Our ref: SSD 5169 MOD2, 12/03480

**Horsley Drive Business Park Subdivision and Infrastructure Works (SSD 5169) – MOD2  
Response to Submissions**

**HORSLEY DRIVE BUSINESS PARK – SSD 5169 MO1– REQUEST FOR MODIFICATION**

RETAINING WALL COMPARISON PLAN
SCALE 1:500
RETAINING WALLS & BUILDING PADS
AS PER APPROVED DA DRAWING
CO114.92.00-DA62 OVERLAYED IN RED

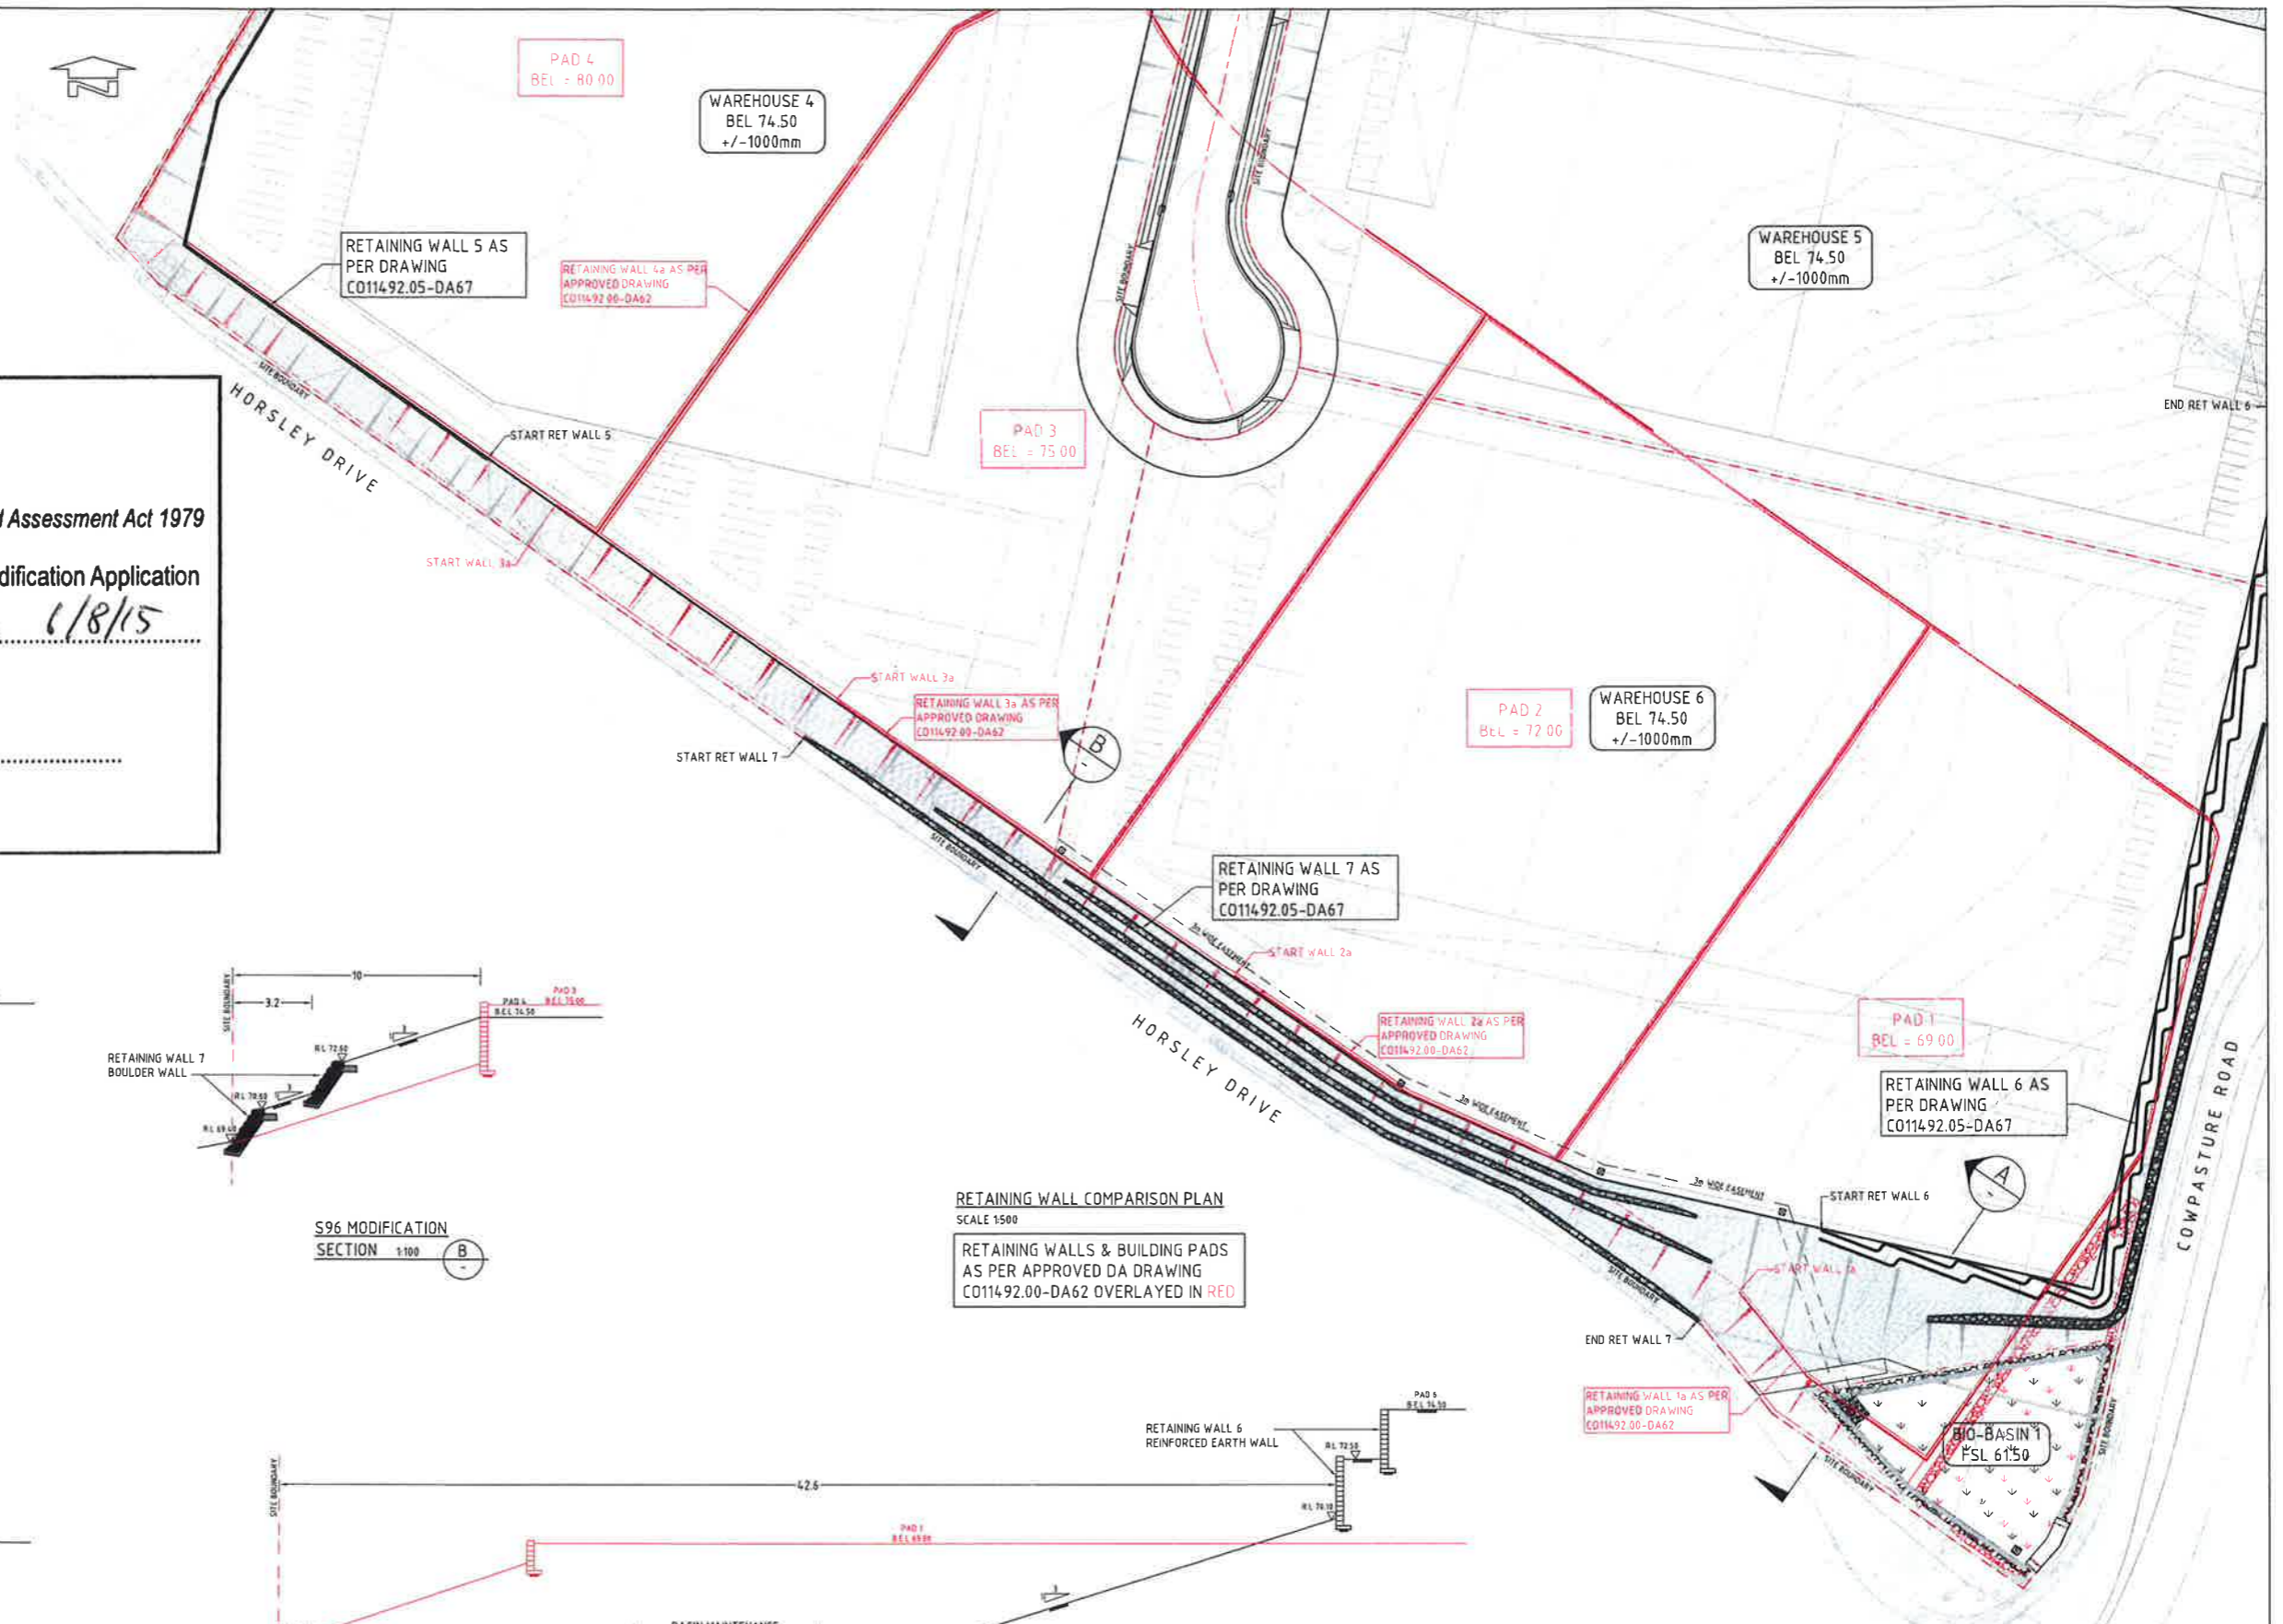
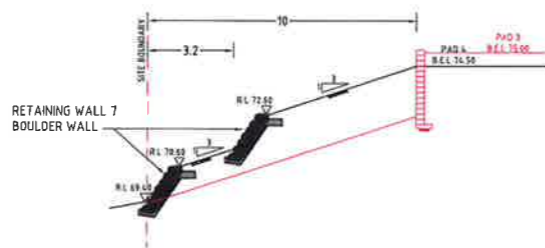
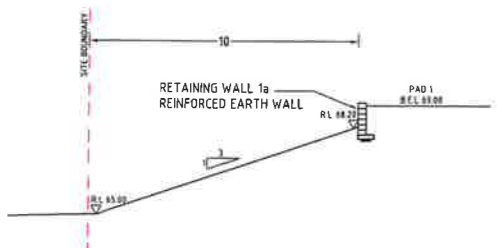
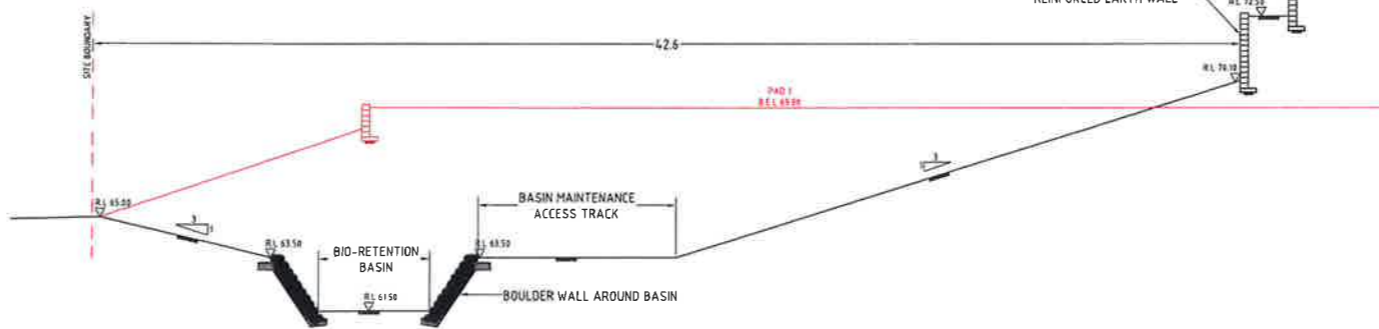
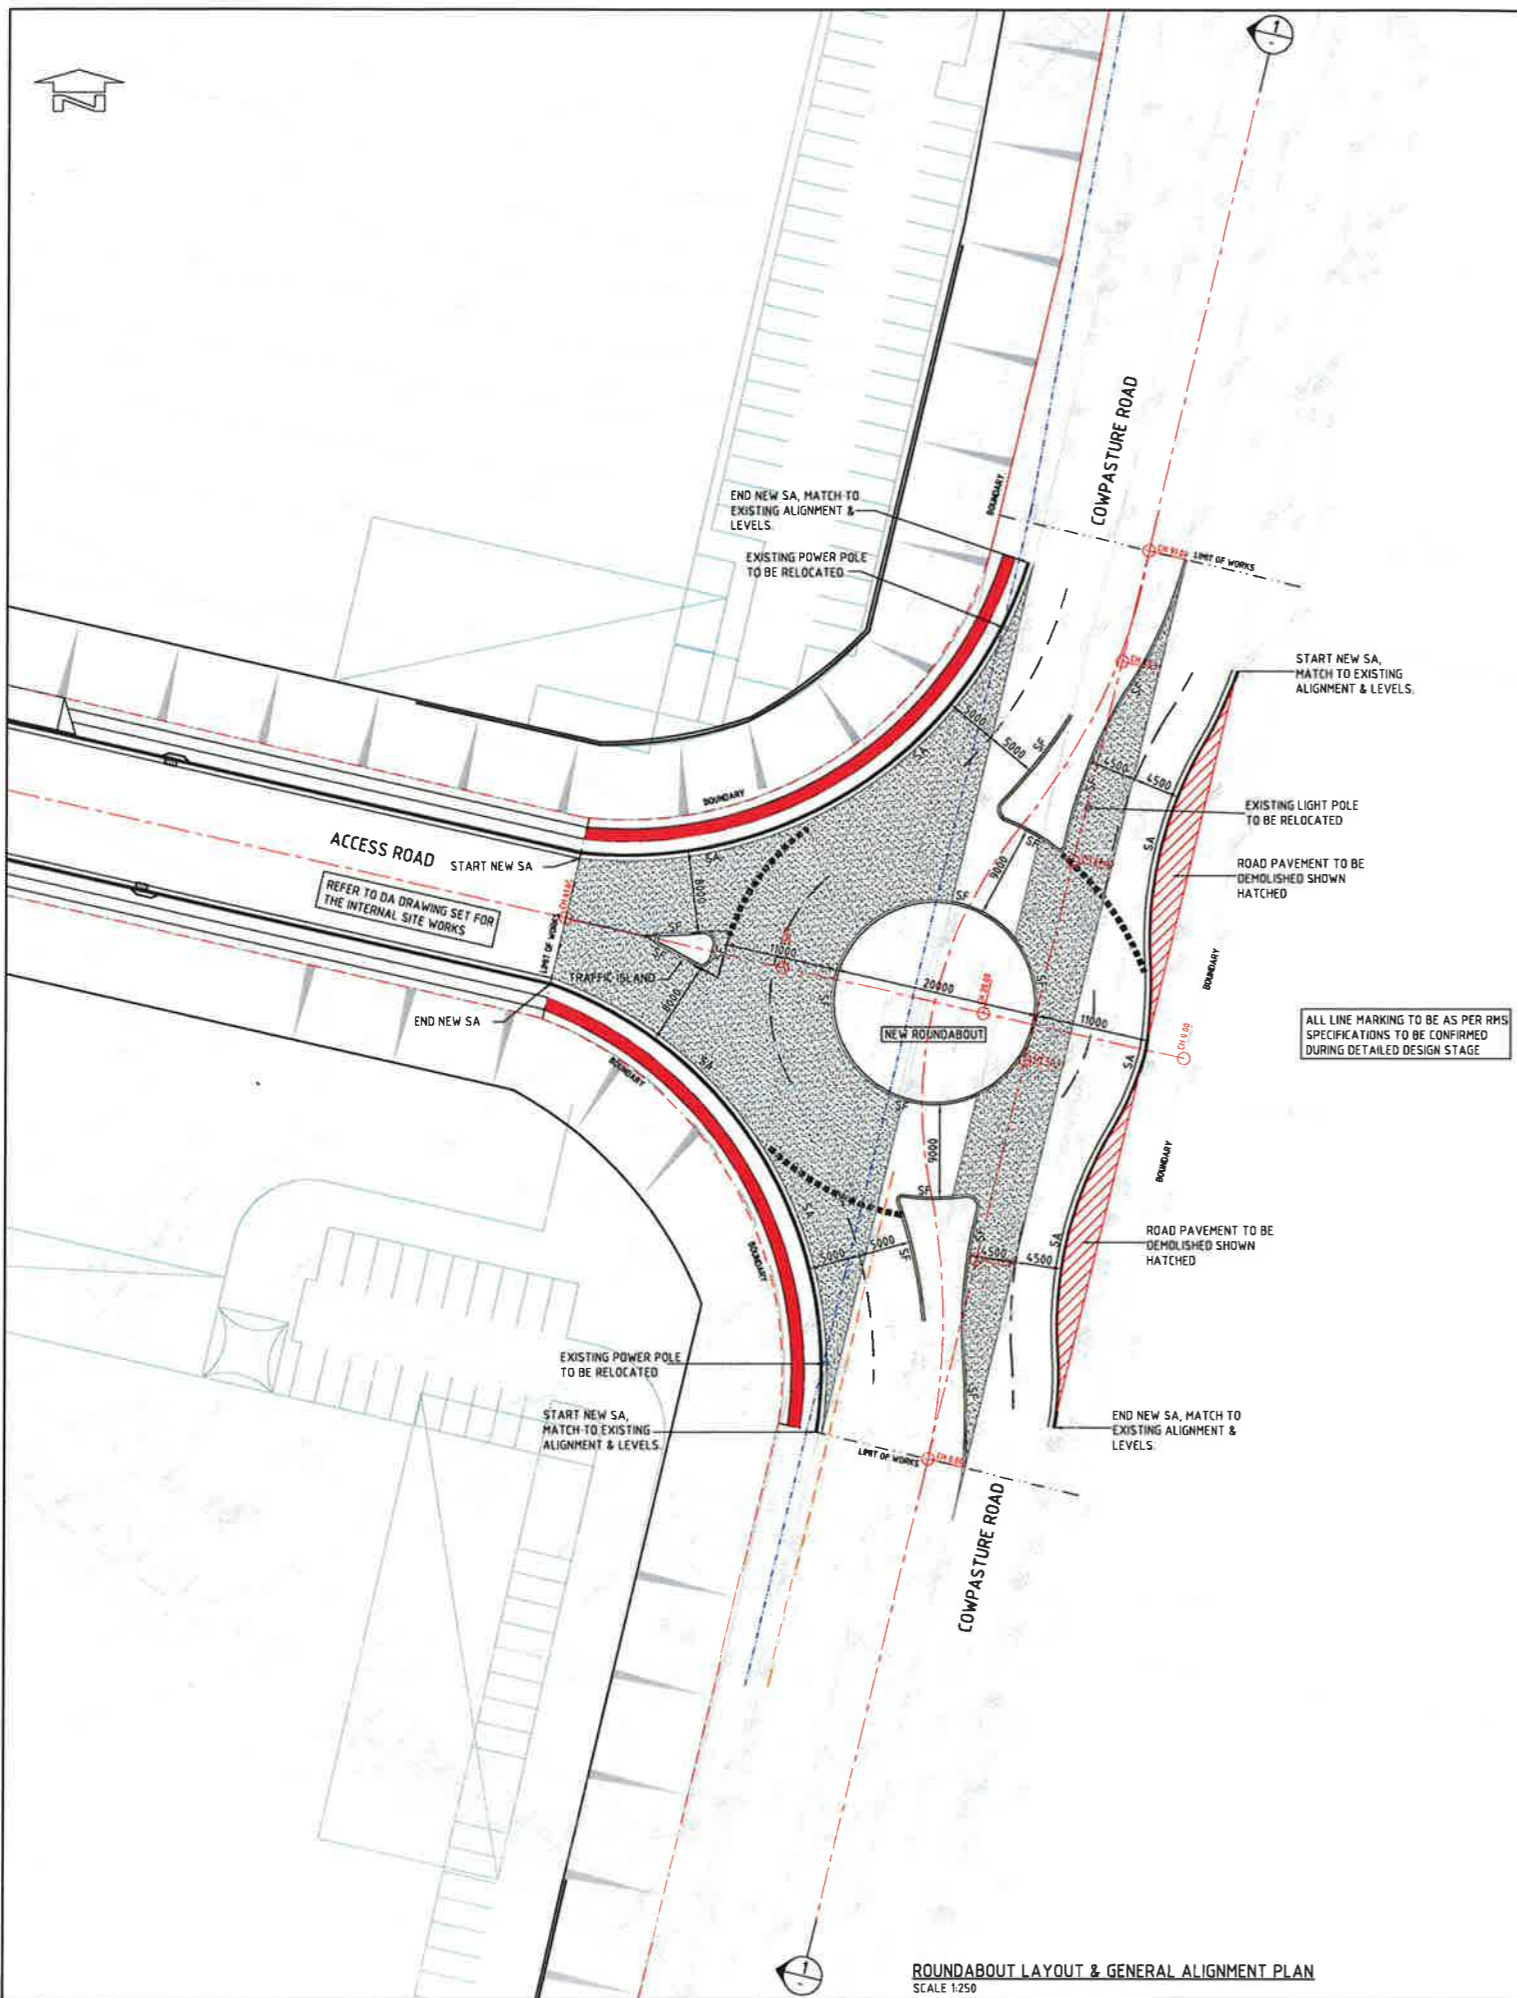
There is concern that the proposed changes to the heights and locations of retaining walls on the site will adversely affect the visual amenity of the site and surrounding locality. The Horsley Drive and the Cowpasture Road frontages of the site are highly visible. The Horsley Drive is the principal western 'Gateway' entrance into Wetherill Park and this frontage also has a strong visual relationship with the parkland area to the south. The gateway and parkland character of the site necessitates a good streetscape presentation in order to complement this character.

The perspective included at Appendix 2 to the modification request of February 2015, and Appendix 5 to the letter dated 5 March 2015, is not indicative of a good streetscape outcome. The height and scale of the proposed retaining walls appear to be overwhelming. While it is assumed that this perspective depicts The Horsley Drive frontage of the site, this is unclear as no indication is provided as to where this perspective is taken from. In the order to address this issue it is requested that you provide:

The landscape plans do not assist in satisfying the Department's streetscape concerns. No elevations to either The Horsley Drive or the Cowpasture Road have been provided. An additional section closer to the corner of The Horsley Drive and Cowpasture Road, where the retaining walls would appear to attain their maximum height, is requested in order to assist the Department's assessment of this issue.

Consideration should also be given to lowering the heights of the proposed retaining walls and bulk earthworks in the vicinity of the corner of The Horsley Drive or the Cowpasture Road in order to facilitate a good urban design outcome.

- The applicant needs to provide further justification as to why the modified retaining walls along Cowpasture Road should be constructed to the proposed height, approximately 4.5metres above the approved height under the approved application.

This should also include justification for the amount of fill now proposed at the south eastern corner of the site. Council officers note that there would appear to be capacity to provide greater balance in the amount of fill along the eastern boundary of the site such that building pads and height of retaining walls could be lowered in the south eastern corner without comprising other site development and infrastructure (i.e. access and site drainage) issues.

In particular it is unclear to Council officers as to why the pads on the southern side of the proposed access road are significantly higher than the pads associated with Stage 1 of the proposal on the northern side of the access road, leading to the excessive height in the pads along Cowpasture Rd resulting in unsatisfactory urban design outcomes in the development.

- The applicant needs to provide additional measures to reduce the bulk and scale of the proposed retaining walls. This includes addressing the need for additional soft landscaped areas, details of the location and depth of planting within the retaining walls.
- The finish of the retaining walls should have a more 'natural' appearance having regard to the setting of the site within the Western Sydney Parklands and gateway position to the Wetherill Park.
- The applicant needs to provide more detailed information including fully dimensioned plans and levels regarding the above.
- The applicant should substantiate as to why the proposed excessive height of the modified retaining walls is able to be dealt as a minor modification under s.96(1A) the EP&A Act
